Recommendation Report for Planning Permission for Works or Extension to a Dwelling

REF NO: FG/30/22/HH

LOCATION: 11A The Grove
Ferring
BN12 5JA

PROPOSAL: Approval for existing front bow window.

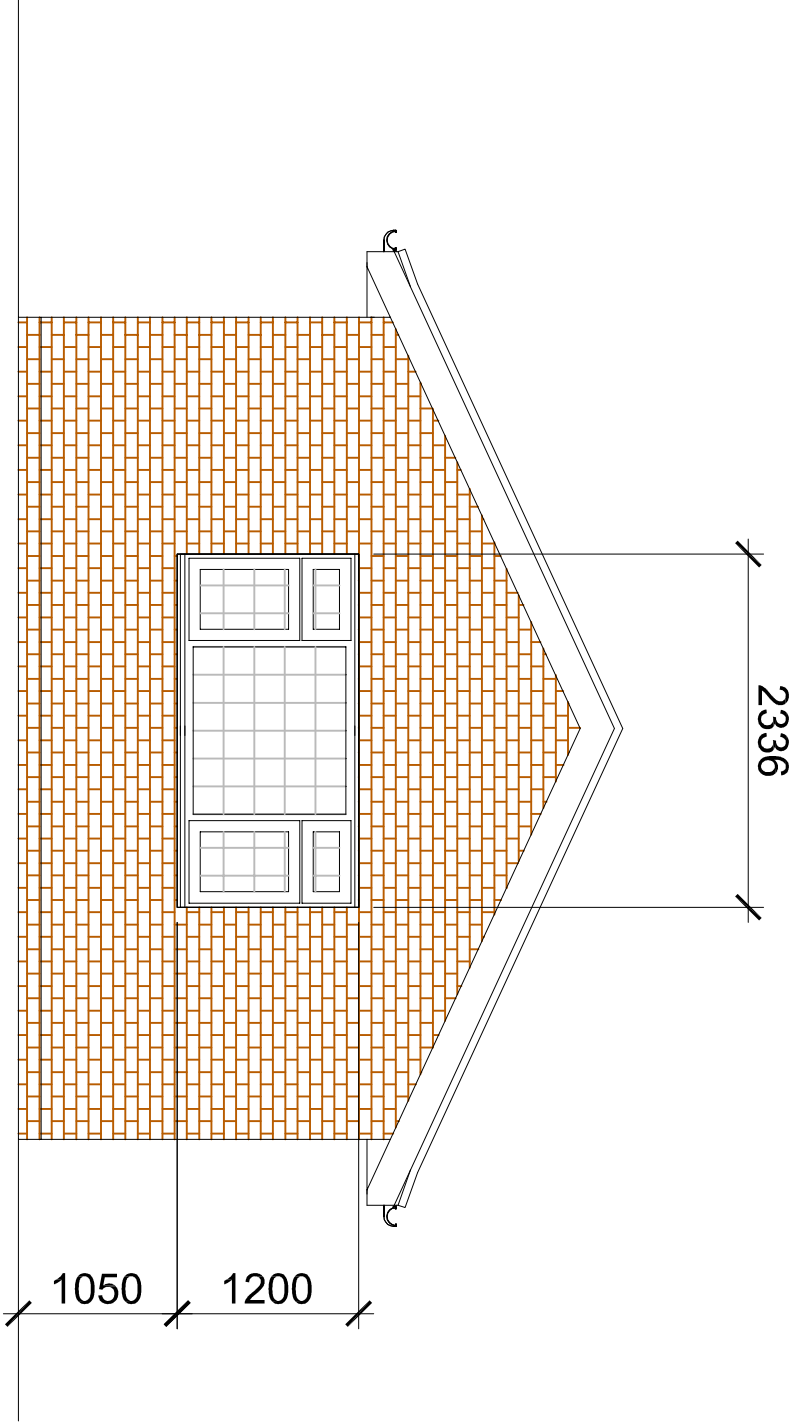
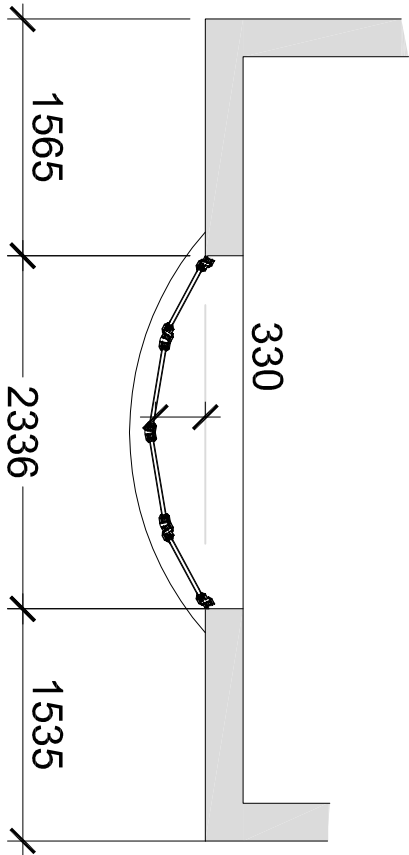
The development has replaced an existing front ground floor window with a bow window. The width of the window remains at approx. 2.34m however, it does feature a decorative panel that sits atop the window, curving around its bow form. This feature displays a slightly larger width of approx. 2.7m. This is a minor scale increase that compliments the window.

The bow window projects forward of the front elevation by approx. 0.5m, a subtle depth increase that is appropriate. The bow window also features a small, 0.4m high support to bottom of the bow window, positioned centrally to support its form.

The bow window is visually subservient and integrated, featuring materials matching to those found on the existing dwelling. There are other examples of small front bow windows within the locality and as such, this is in keeping with the character of the area. It is a complimentary feature and a positive addition to the street scene.
